**Tritax application re Hinckley National Rail Freight Interchange (HNRFI)**

**Interested Party Reference No. 20037843**

**1. Sapcote Village Centre**

**Sapcote Enhanced Scheme
Appendix C (part 5)
Vehicle Tracking Sheet 1**

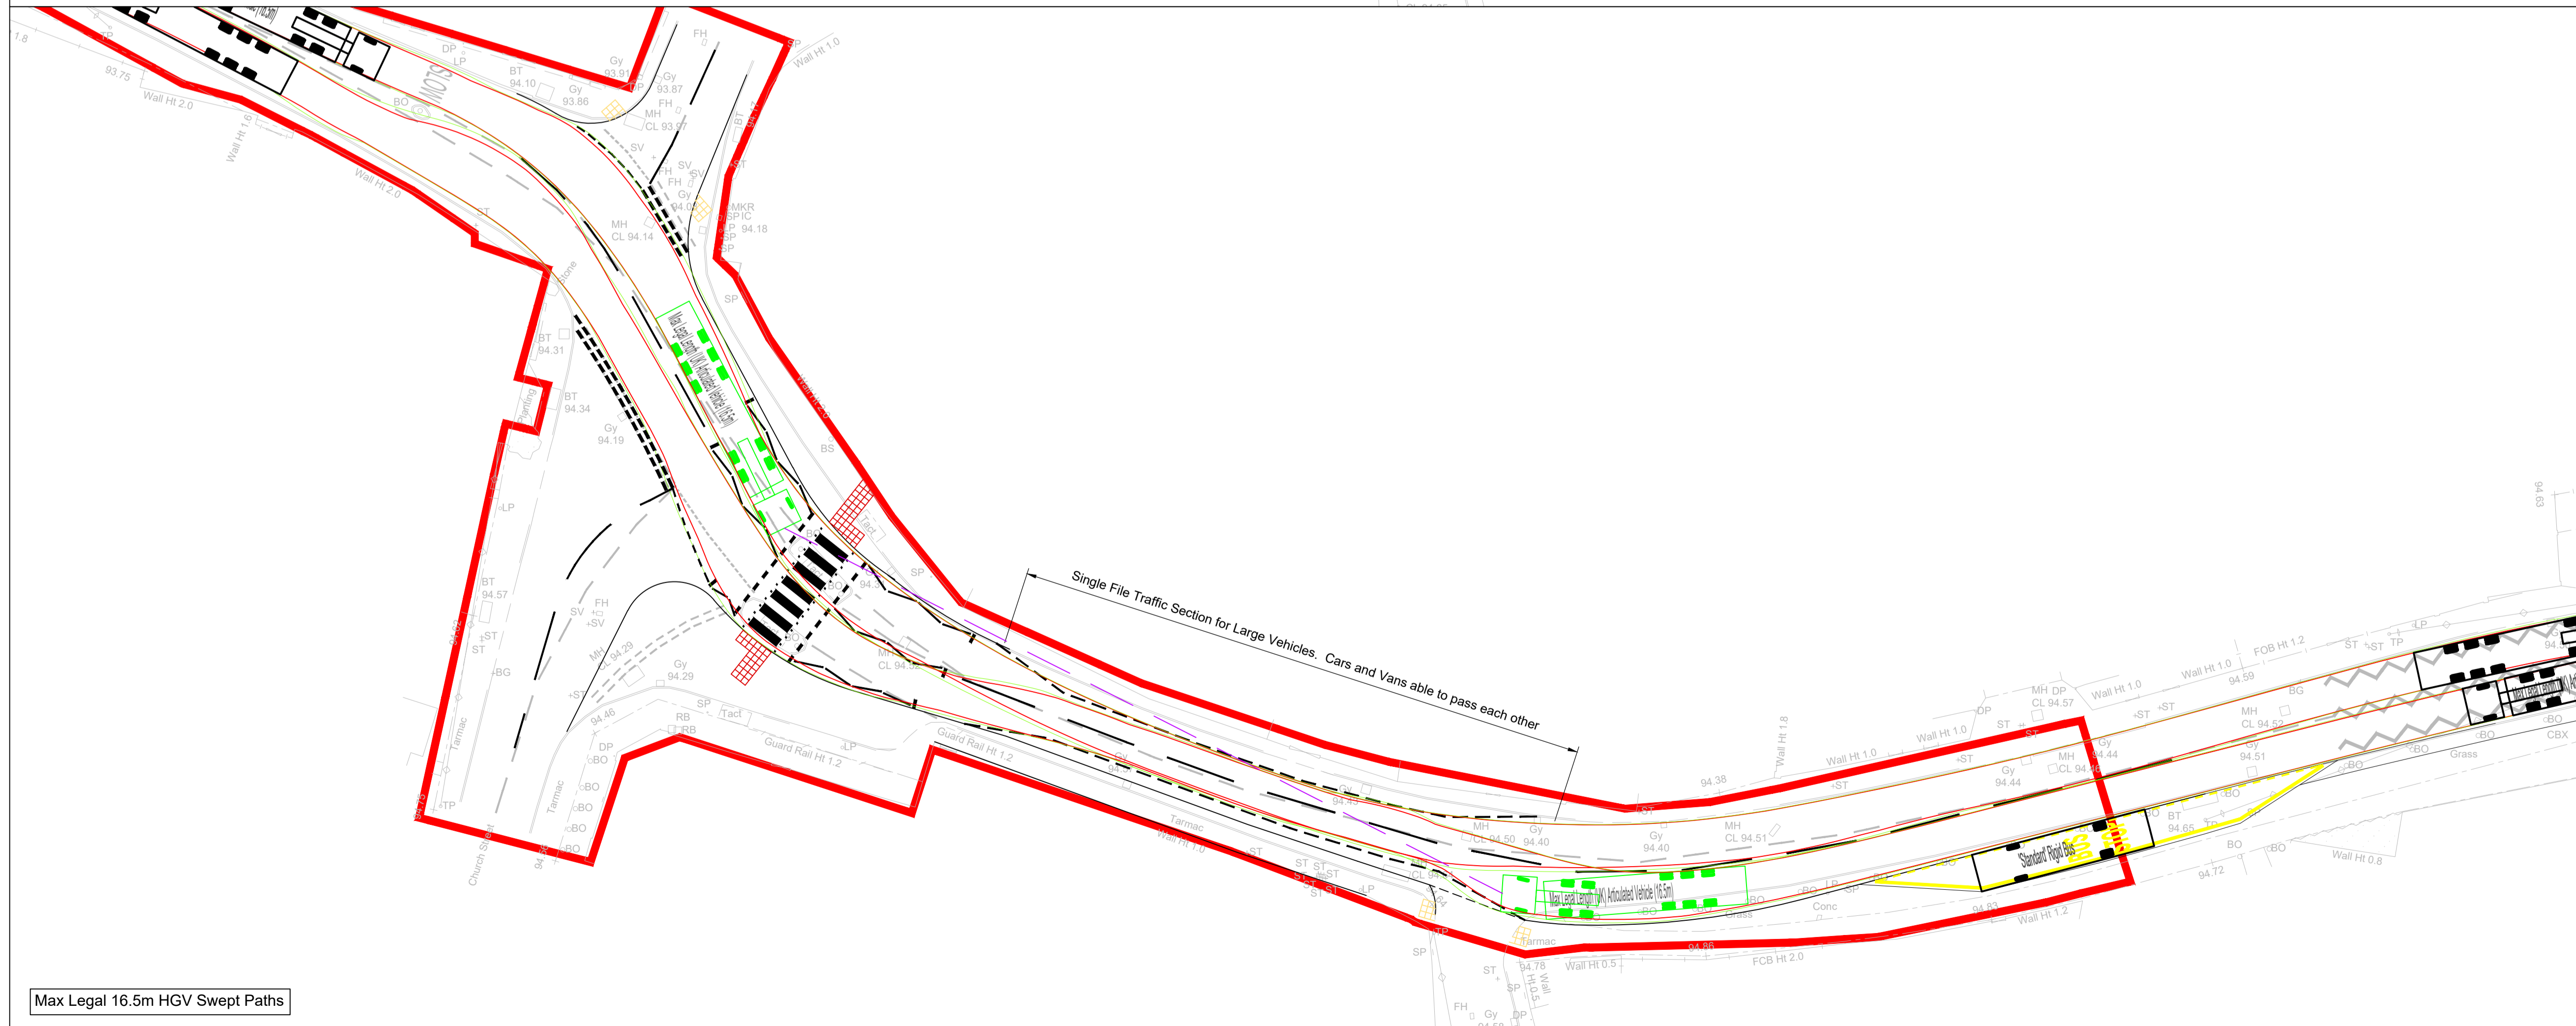
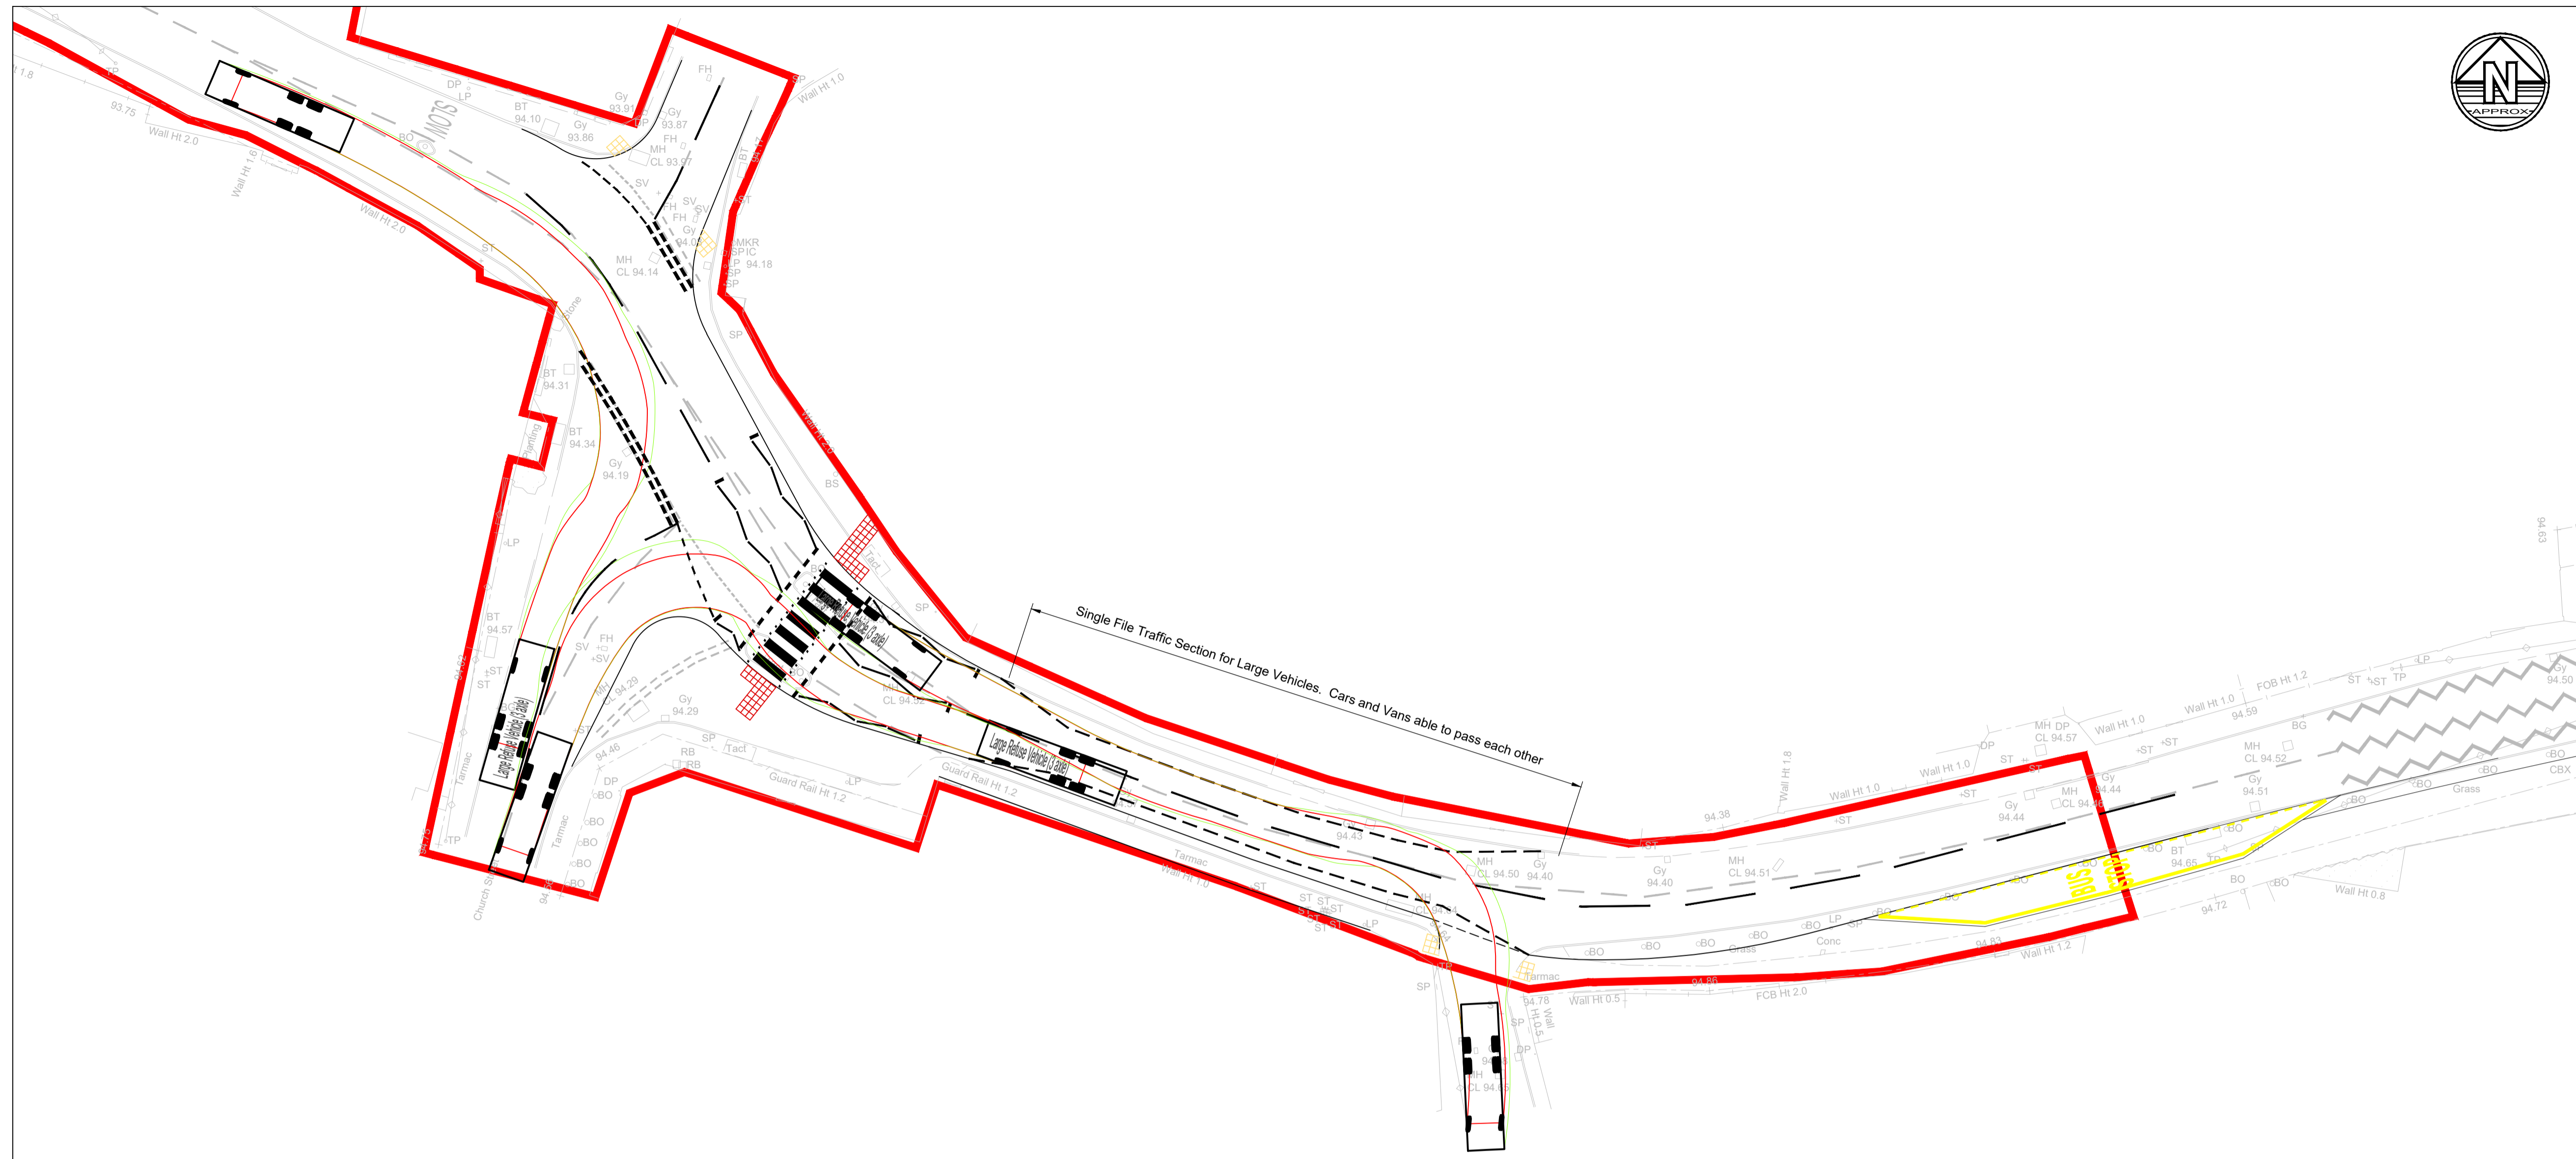
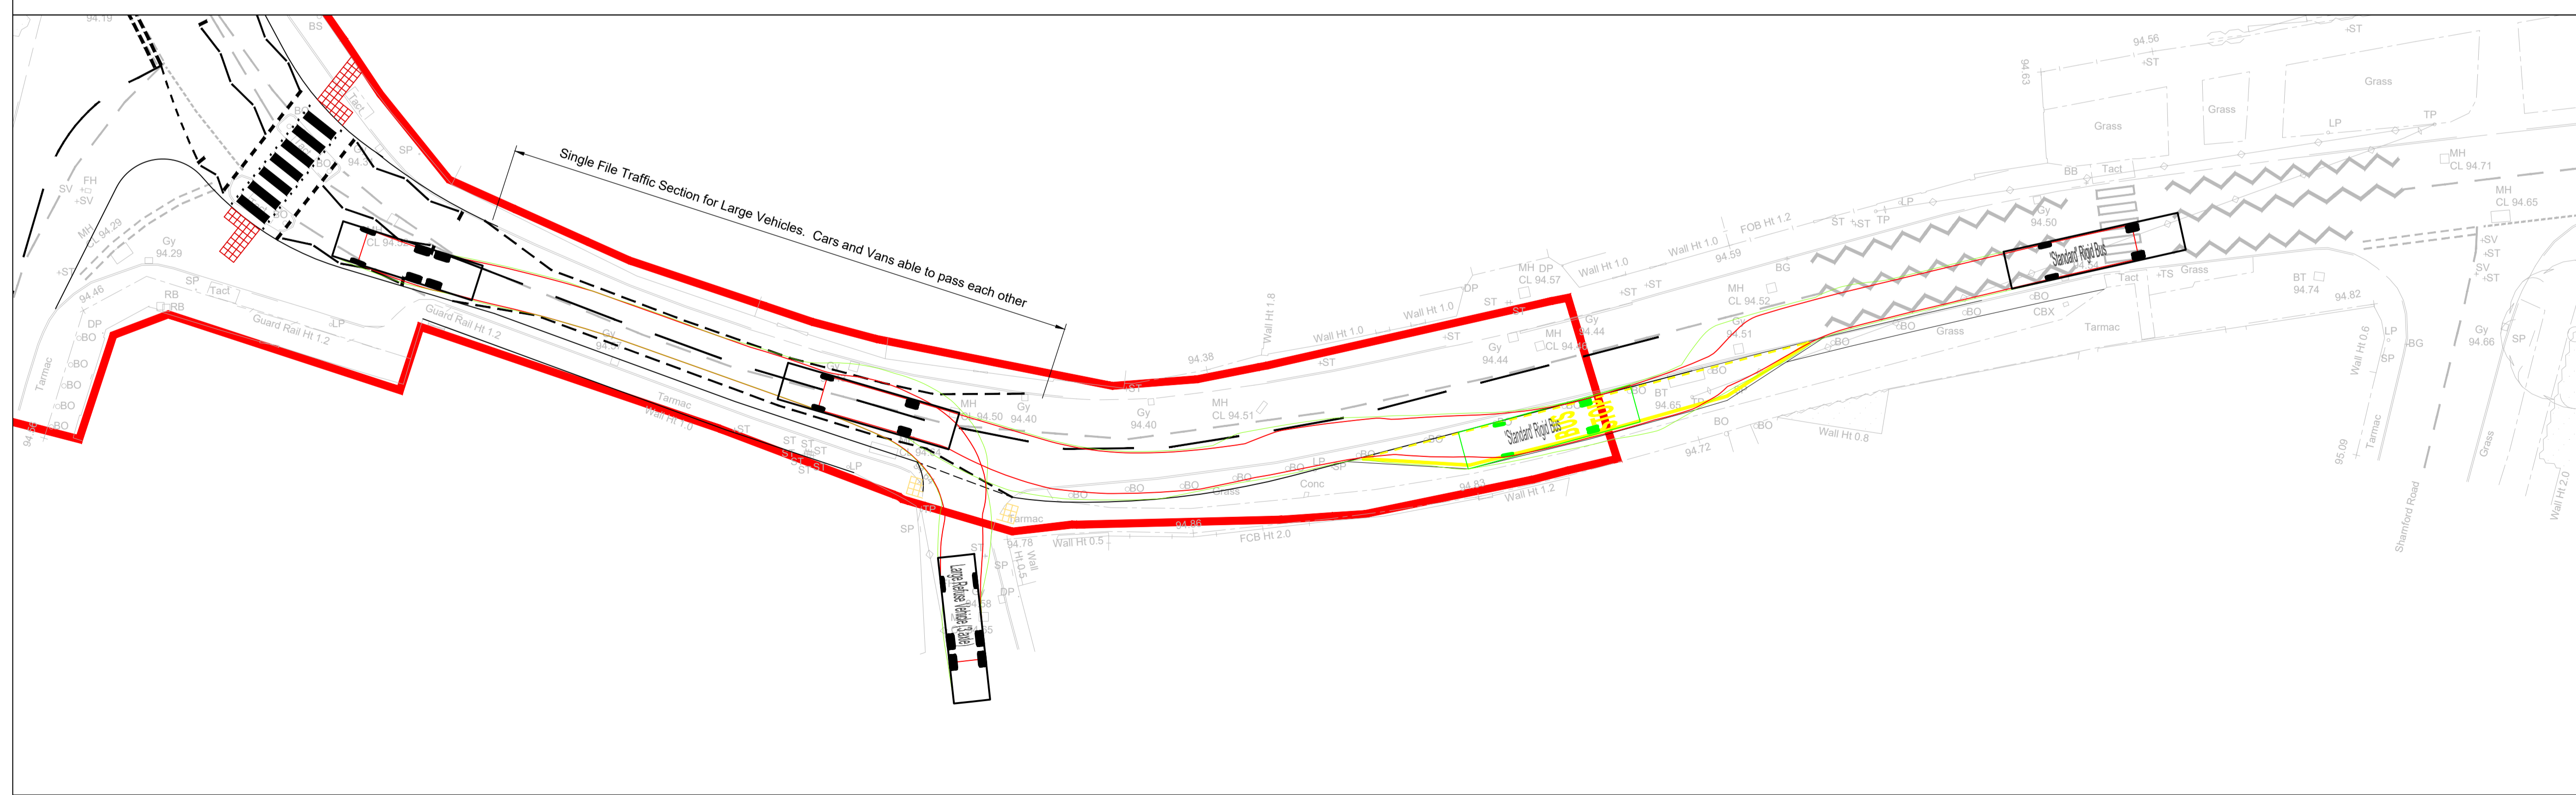
- b. The proposal to deal with the section of road between the Co-op and New Walk by reducing the width of the carriageway so that HGVs realise there is insufficient room for them to pass and wait for the oncoming HGV sounds dangerous in the extreme. It relies on the HGV drivers actually doing this and not trying to pass anyway – in which case they would still mount the kerbs. Also, as LCC point out (Sapcote Technical Note 6.59), it is unclear how, if one HGV does not stop to let an oncoming HGV through, they could then safely reverse to remedy the situation. The scheme coincides with a major blind spot at the eastern end of the Co-op, so cars driving round the bend from the direction of Hinckley will suddenly be faced with HGVs driving towards them down the middle of the road. It is also unclear whether the reduced width of carriageway will continue to be sufficient to allow two cars to pass as we move towards wider electric cars. If this is not the case, then the length of ensuing tailbacks would be wholly unacceptable.
